ADC PARKS & GREENSPACE ARBORICULTURE

PLANNING APPLICATION: FP/173/14/T

ADDRESS: 10 Wick Lane Felpham PO22 8QG

BRIEF DESCRIPTION: Reduce branches to growth points by no more than 2m, raise canopy to 2m above ground level & deadwood 1 No Box Elder tree

◯ BOX ELDER
REQUIRING
ATTENTION.

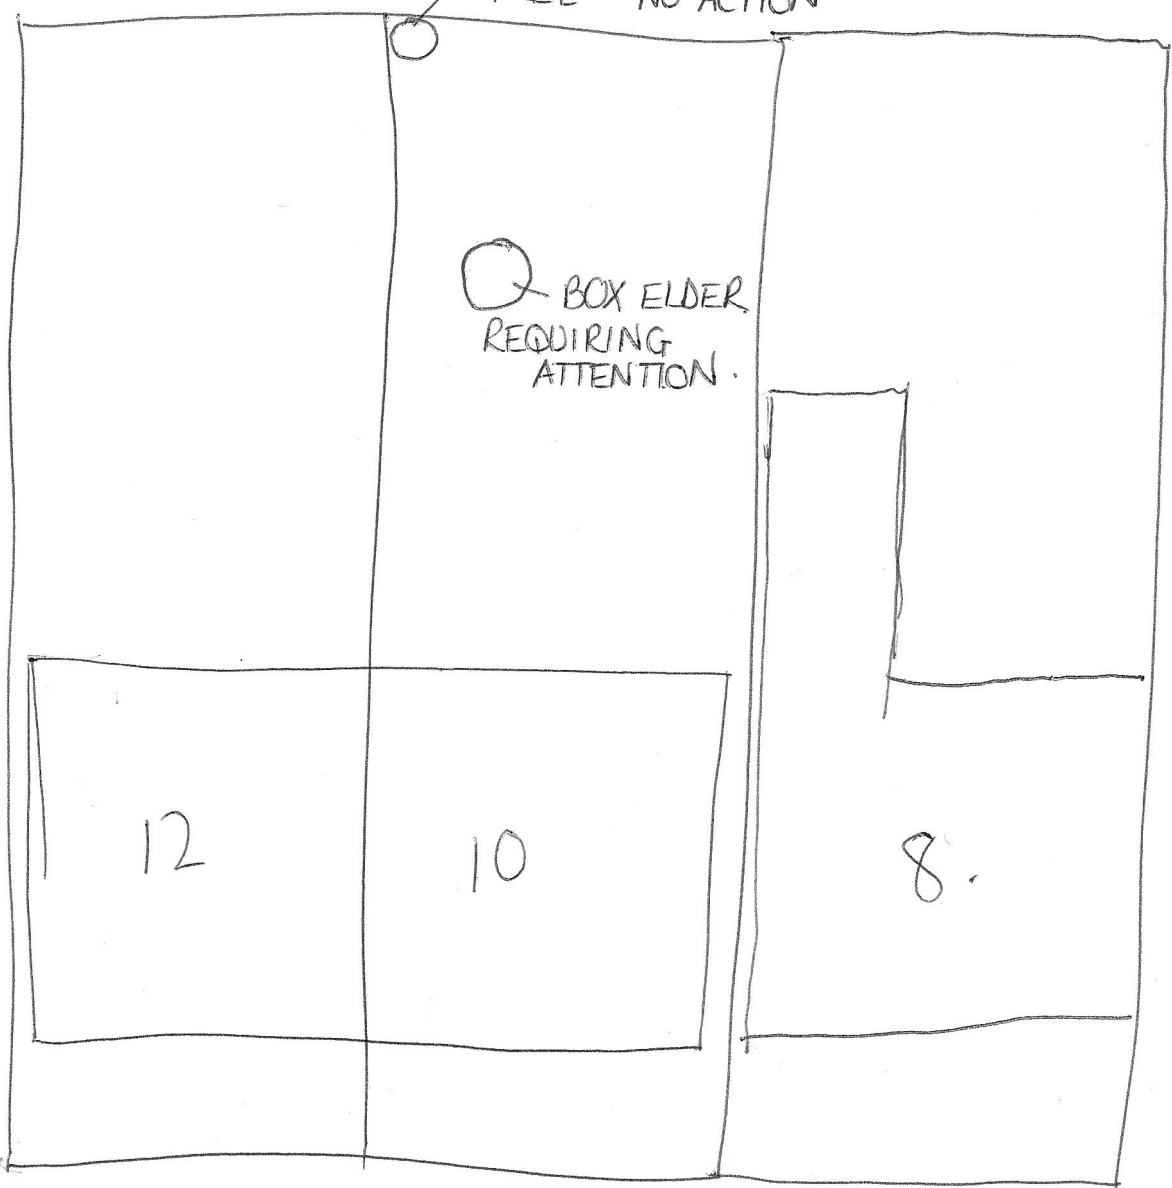
- It is clear for the photographic evidence provided that this a maturing specimen, with a good form and crown condition. There is evidence that this individual has had a remedial pruning operation at some point. This is reflected in the stature of said tree.

- A mature tree of this species would be quite happy with the outlined pruning activity (due to its growth habit being favourable to pruning operations), as the combine lateral reduction and crown reduction would see less than 30% of the healthy crown mass removed (as stipulated to the BS 3998:2010 section 7.6).

- **I would therefore have no objection to the desired pruning works** (both crown raise and crown reduction), as they do not contravene the BS 3998 and would be a technique of potentially extending the retention span of the outlined tree.
- Also the applicant has applied to prune deadwood - **no application needs to be made for this activity.**

All side branches to be retained should be at least **1/3rd** in diameter of the removed branch. Pruning cuts must be flat and smooth, kept as small as possible by cutting at an optimum angle and should not exceed **100mm** in diameter.

The Crown Clean should consist of deadwood and stub removal where all cuts should be made to the branch collar. Where crossing branches are encountered the weaker branch/branches should be reduced or removed to avoid contact between them. The remaining branch/branches should be shortened as appropriate to relieve 'end weight' and sudden exposure by reducing the leaf bearing branch tips by no more than 30%.

Branches found within the clearance height having diameters greater than **100mm** should be shortened and no more than 15% of the leaf bearing growth of that branch should be removed to facilitate the unobstructed free passage of vehicles and pedestrians.
